**Ingleburn Resource Recovery Facility (SSD 8593)
Response to Submissions**

Attachment 1: Additional Information

CATCHMENT PLAN
16 KERR ROAD,
INGLEBURN
BRS

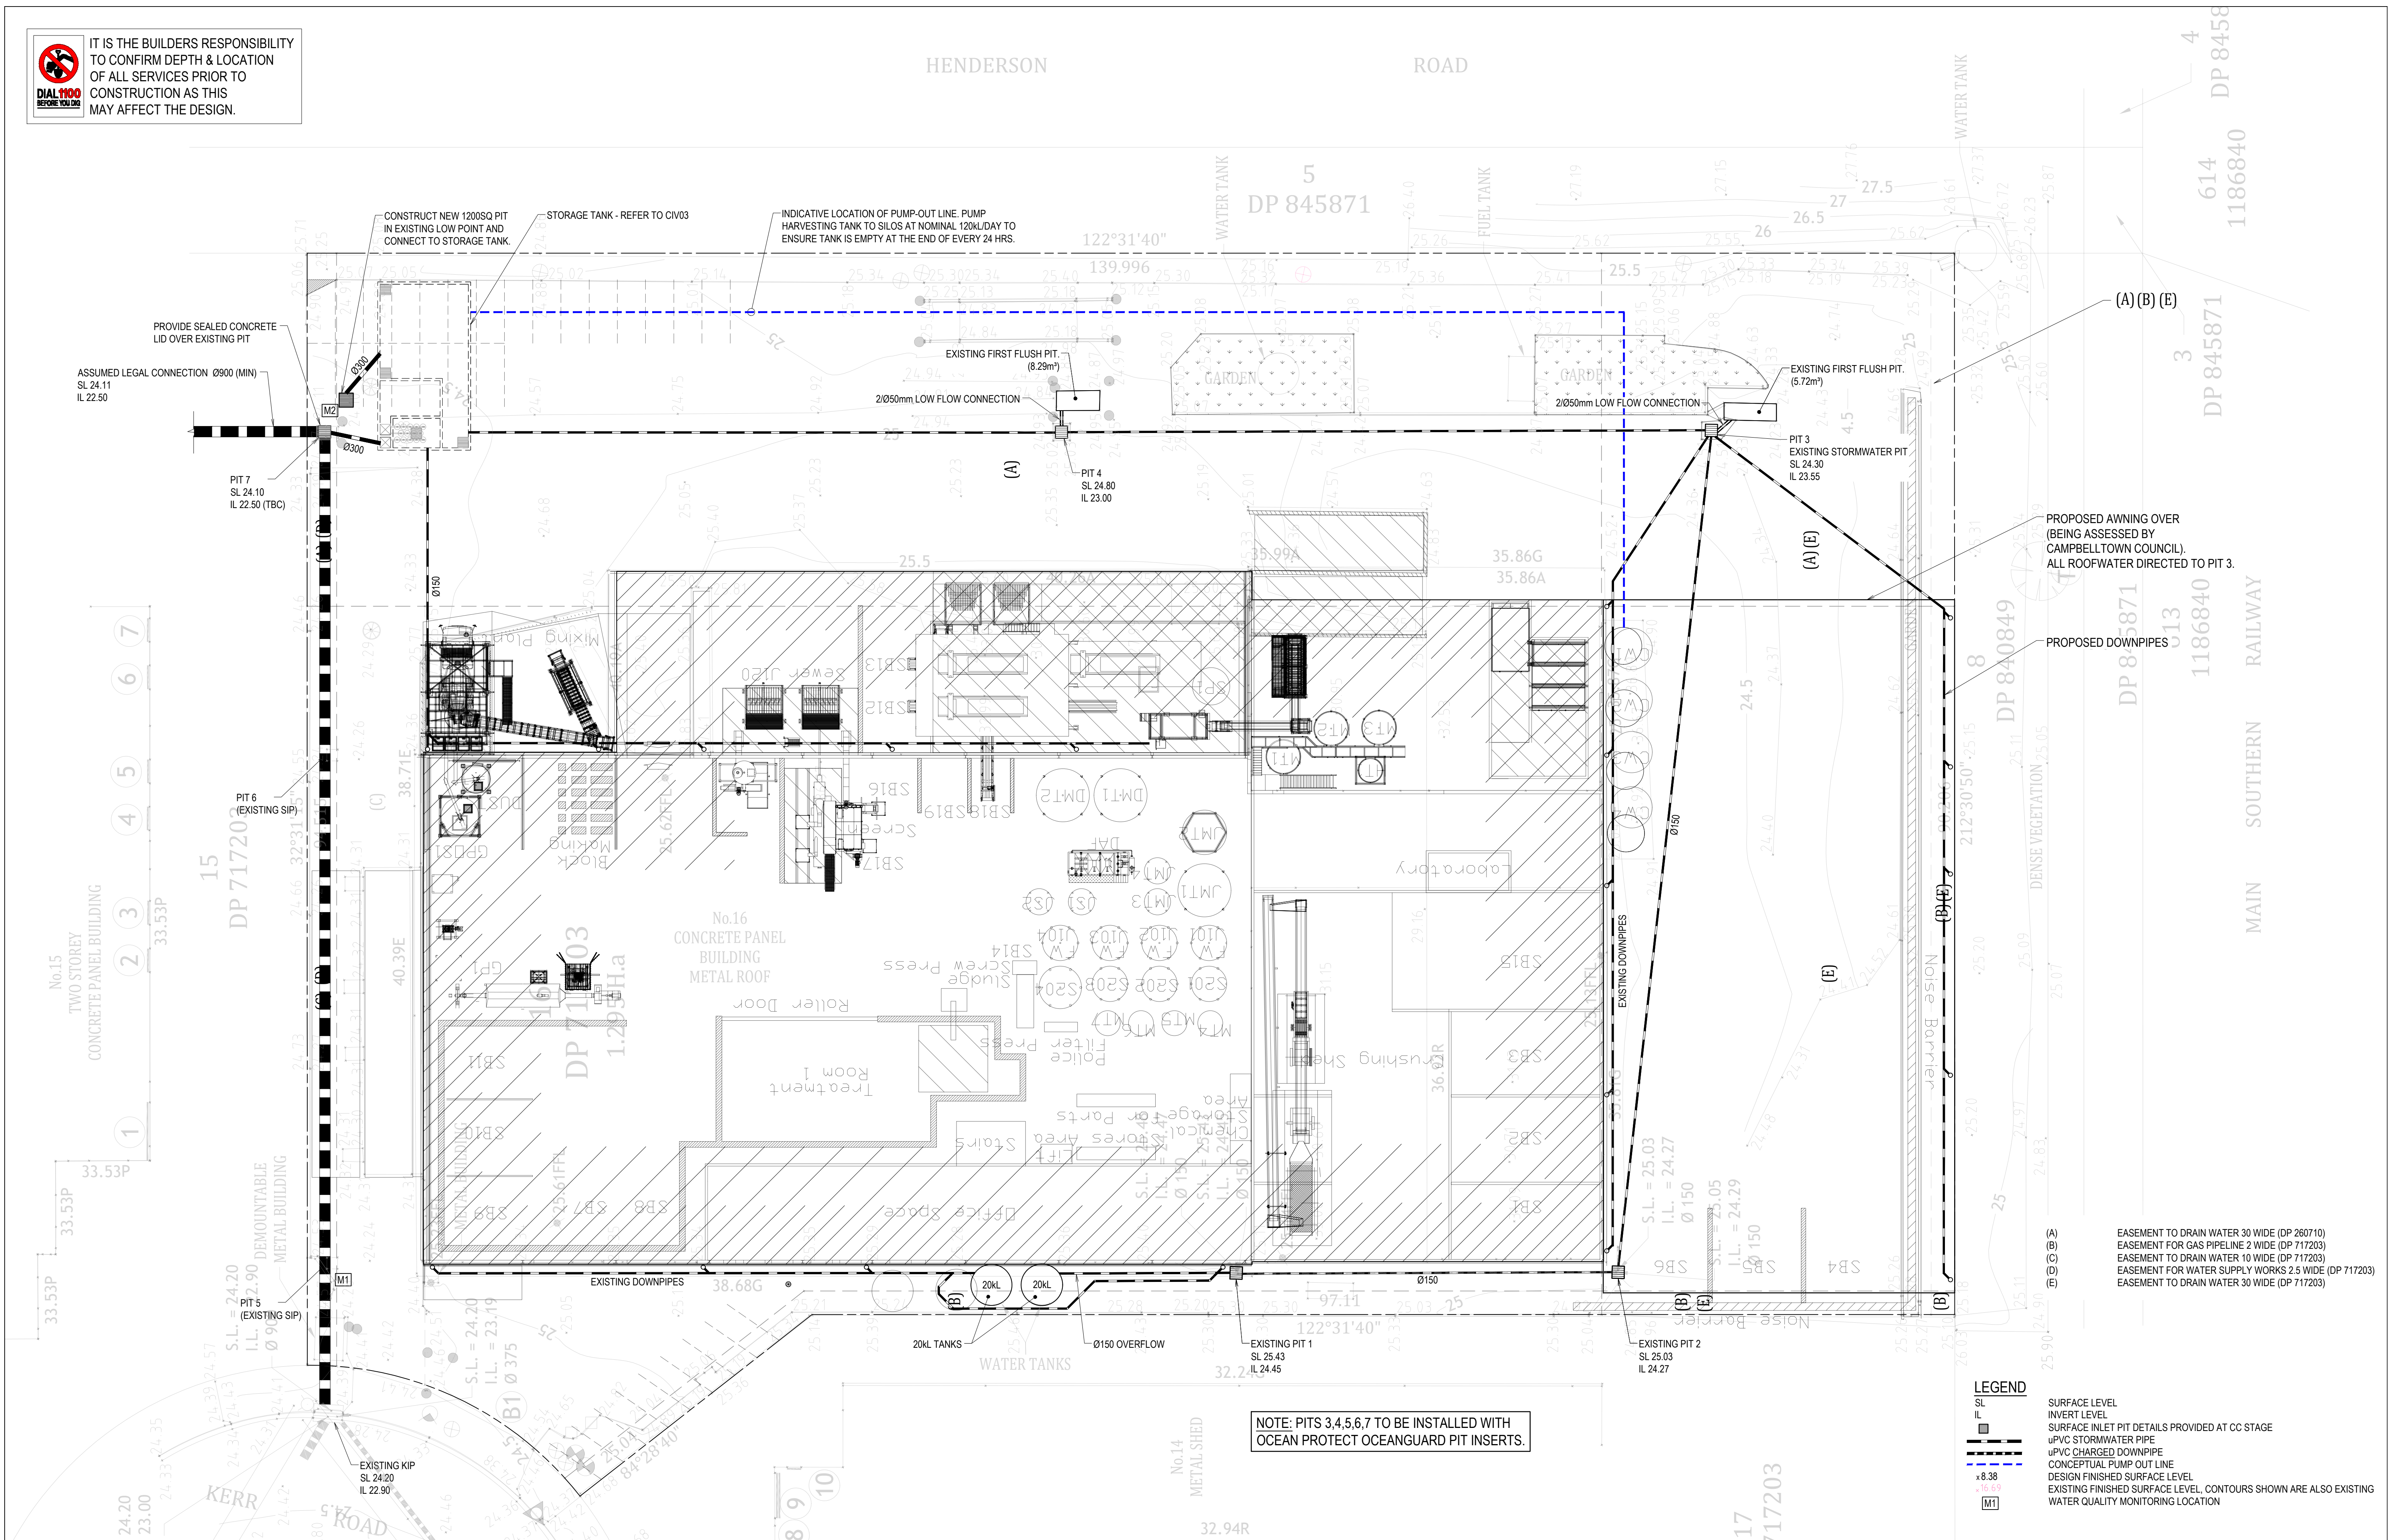
- The Water Management Plan and Water Balance (Appendix B) does not model or discuss water quality including potential contaminants of concern. The proposal does not include separate leachate collection for external stockpiles and stormwater systems. Therefore, contaminants from the waste stockpiles are directed to the stormwater system. How leachate or dirty water be managed on site to prevent pollution of waters?

- Provide a characterisation of water run-off from the stockpiles is provided, taking into account the stockpiles are located in an overland flow path.

- The Water Management Plan does not discuss the impacts of the proposal on the overland flow of water.

- Where is the OSD tanks proposed?
